From: [Cattier, Sophie](#)
To: [East Anglia Two](#)
Cc: [Fletcher, Will](#); [Robinson, Joanne](#)
Subject: East Anglia TWO Offshore Windfarm - EN010078
Date: 02 November 2020 18:32:39
Attachments: [Historic England Written Reps EA2 Fin.pdf](#)

**REPRESENTATIONS OF THE HISTORIC BUILDINGS AND MONUMENTS
COMMISSION FOR ENGLAND (HISTORIC ENGLAND)**

**APPLICATION BY EAST ANGLIA TWO LIMITED FOR AN ORDER GRANTING
DEVELOPMENT CONSENT FOR THE EAST ANGLIA TWO OFFSHORE WIND
FARM**

APPLICATION REF: EN010077 (EA1N) & EN010078 (EA2)

Figure 5: Outline Landscape Mitigation Plan and Relevant Heritage Assets in the vicinity of Friston

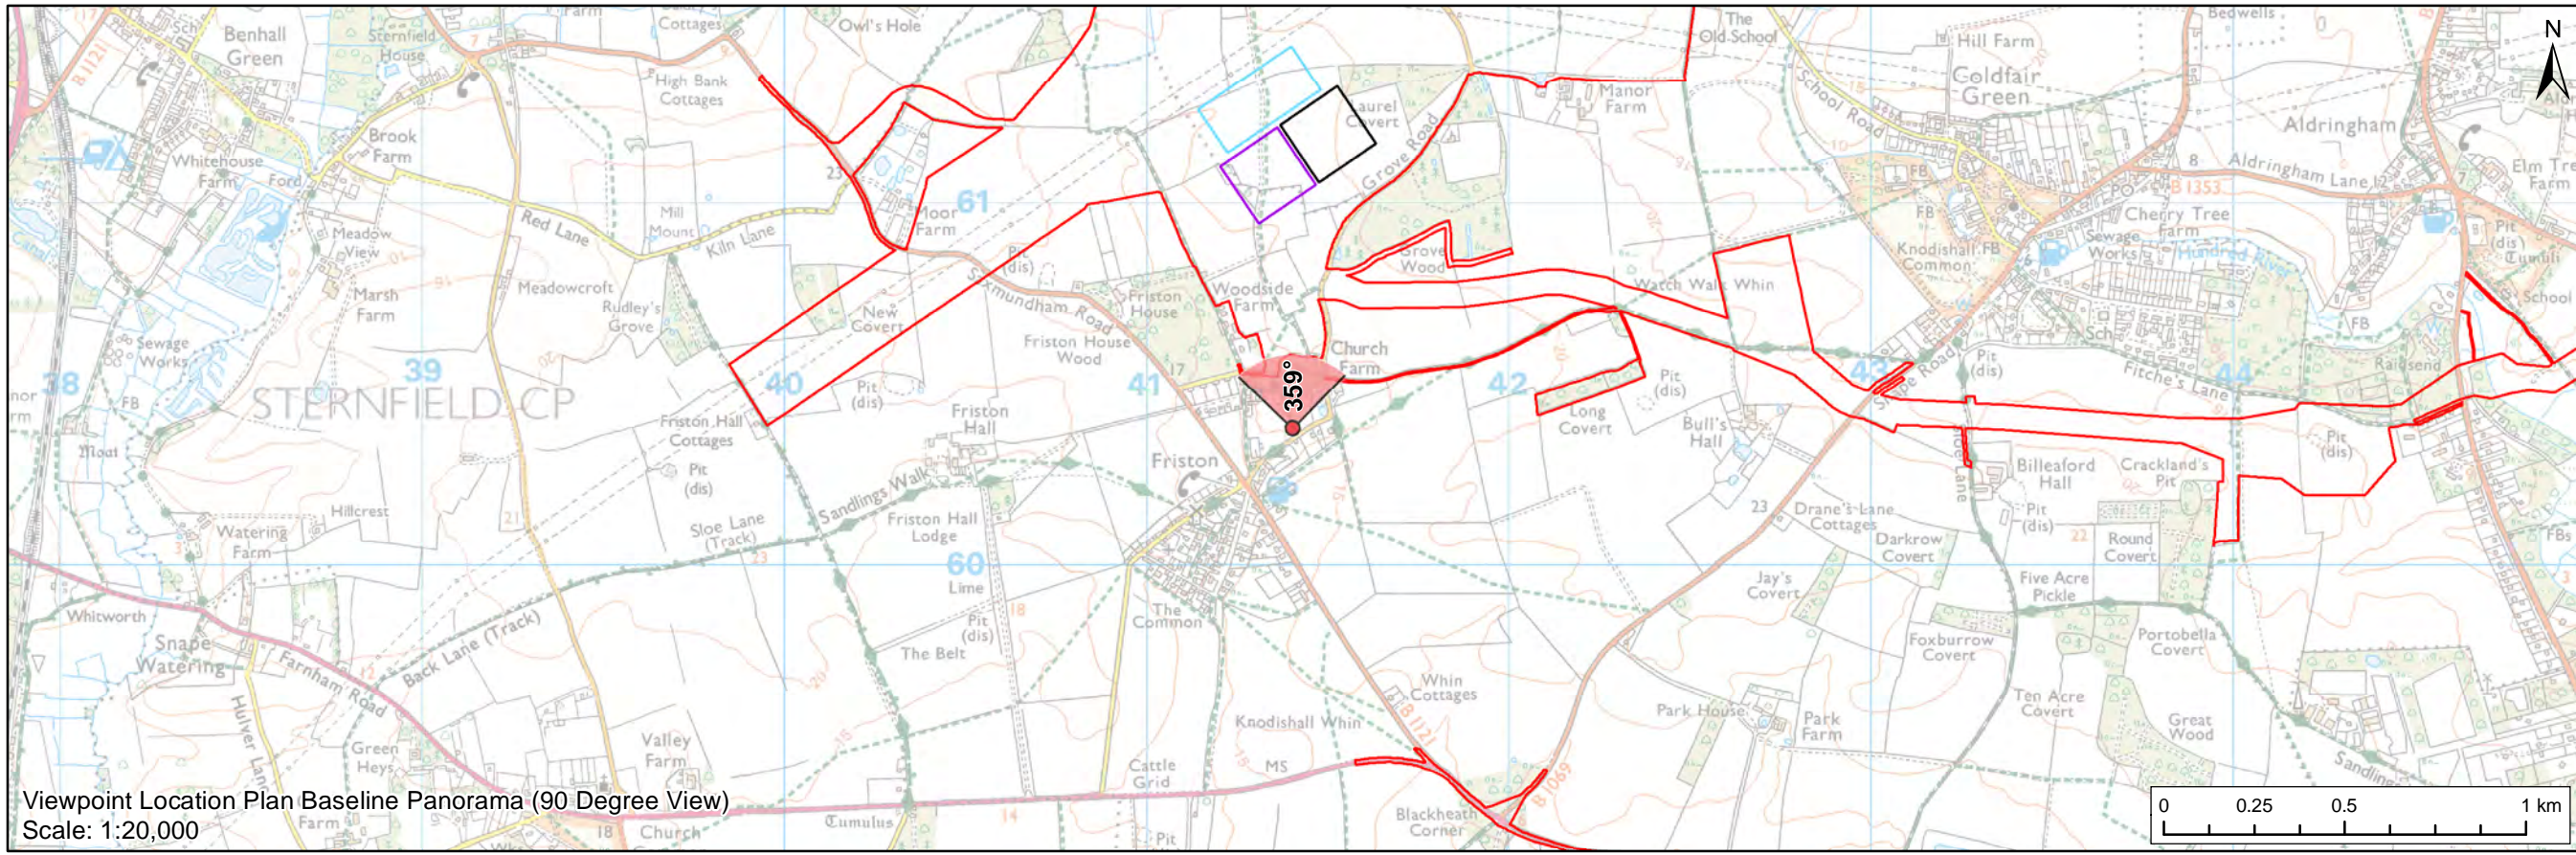
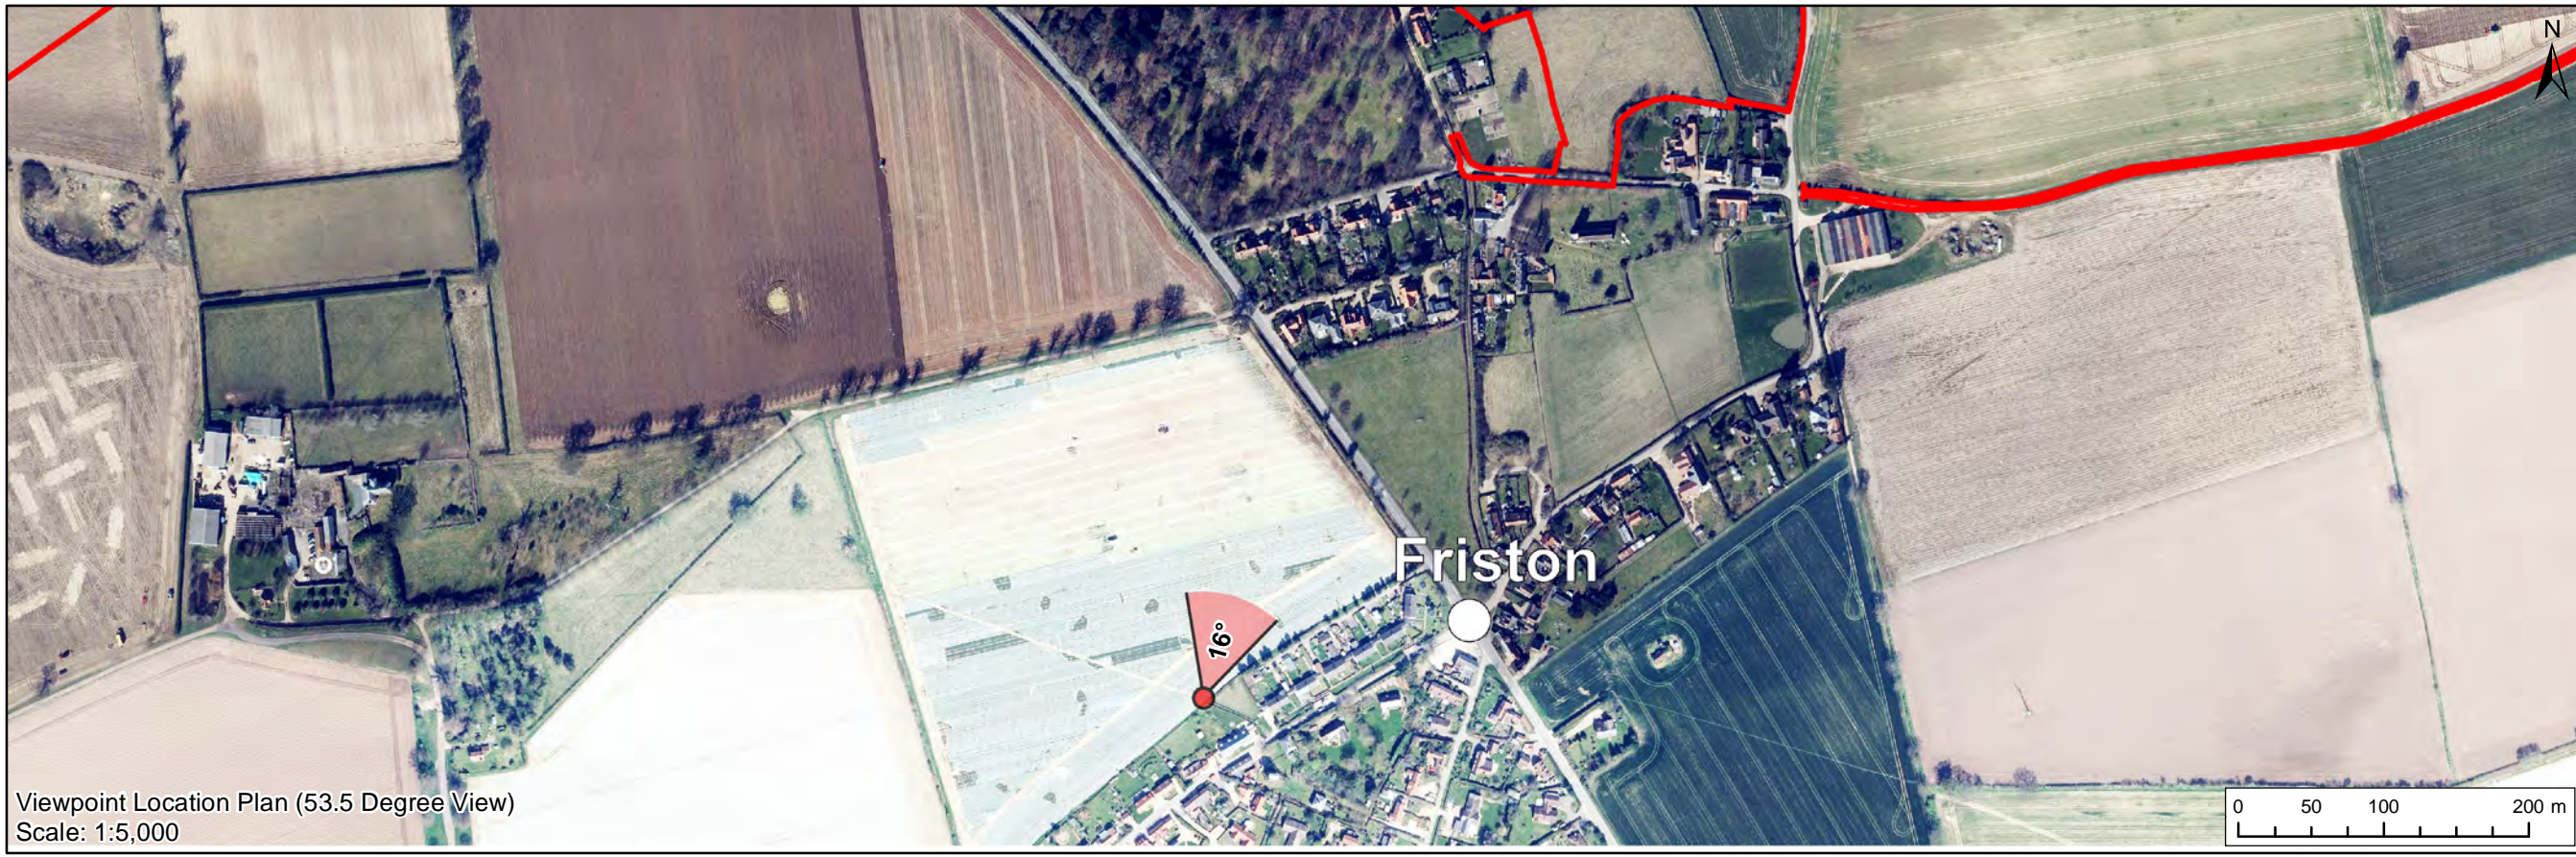
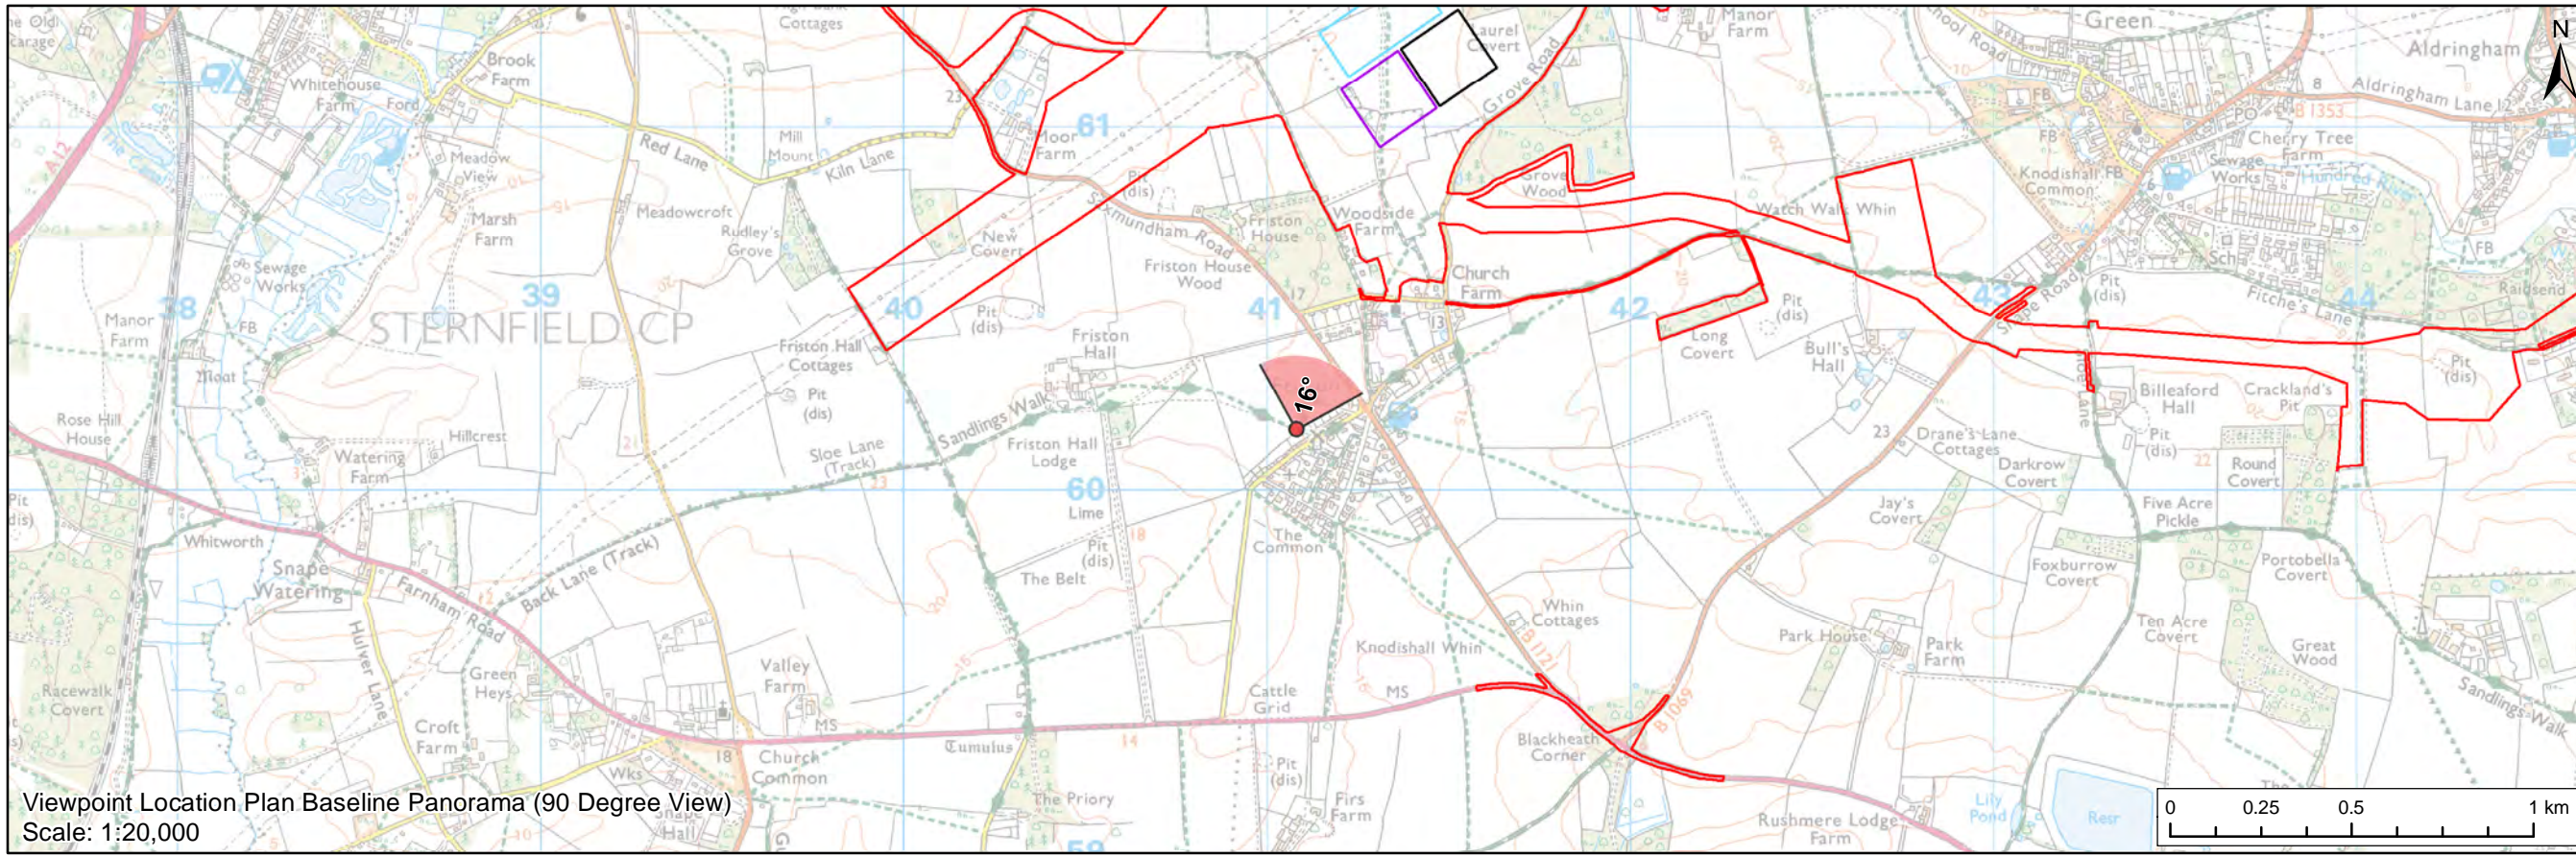
- 2.3.3. The view is more open from Church Road across the open landscape with some trees, hedges and woodland to the east. The power line which crosses this part of the countryside is also visible in the current landscape. The visualisation however again demonstrates the appearance of the substation in particular its scale and mass. The existing hedge line screens the lower part of the development but it starkly contrasts with the natural landscape. The proposed planting along the hedge line would strengthen this vegetation line to filter more of the development. However filtered views above the hedge line would exist and parts of the development would remain visible between and through the planting.

Drawing file: published-documents / EN010078-001386-6.2.29.13 EA2 ES Figure 29.13 Viewpoint 1 PRoW near Friston House (with National Grid AIS Substation).pdf

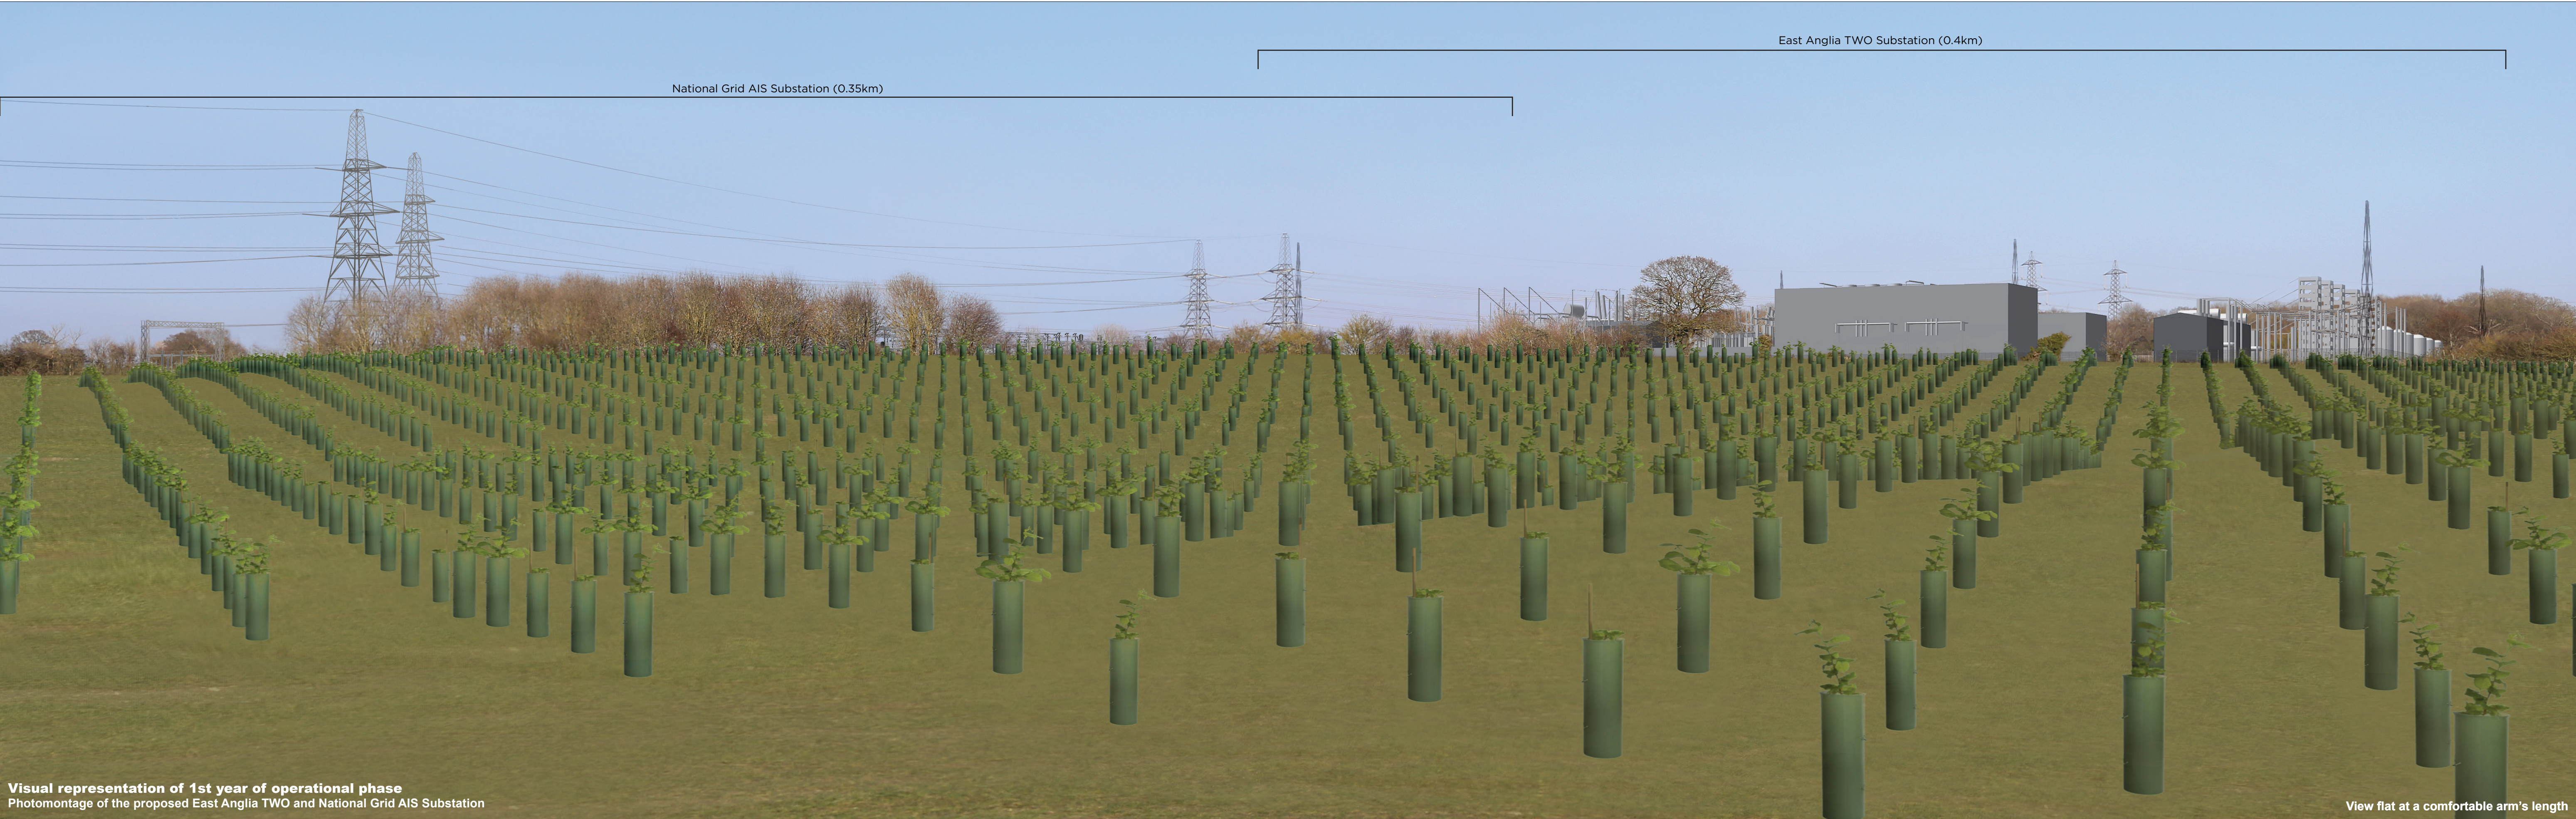
- 2.3.4. The development would affect the experience and views of the church from the land to the north. Here it would change the character of the landscape from rural agricultural land and erode the rural landscape setting of the church. The development would form a visually dominant group of structures in the landscape. There are clear views of the church across this landscape and the visibility and alien nature of the development would compromise and obscure views of the building. This impact can be seen in the viewpoints 1, 4, 5 and 8. (ES Figures 29.13, 29.16, 29.17 & 29.18).

- 2.3.5. Viewpoint 1 is taken from the public right of way near Friston House (which is also listed at Grade II). This is just to the south west of the substation site and gives a clear indication of the nature of the proposed development. It shows the change in the character of the land were the development to be consented. The landscape is currently a rural, agricultural landscape comprising open fields, hedges and areas of woodland. It is traversed by existing power lines supported by pairs of pylons. These detract from the rural landscape to some degree; however the substation development would have a far greater impact. It would occupy a larger footprint on the ground with a denser arrangement of more solid

structures including silos, towers and enclosed structures. This would radically alter the nature of the landscape from rural farmland to that of a large energy substation. This illustration demonstrates how the development would clearly erode the rural landscape within which the church is experienced. The visualisation with planting mitigation after 15 years shows the planting would screen much of development in this particular view. However, the impact on the experience of the church from this area would persist for the lifetime of the project.
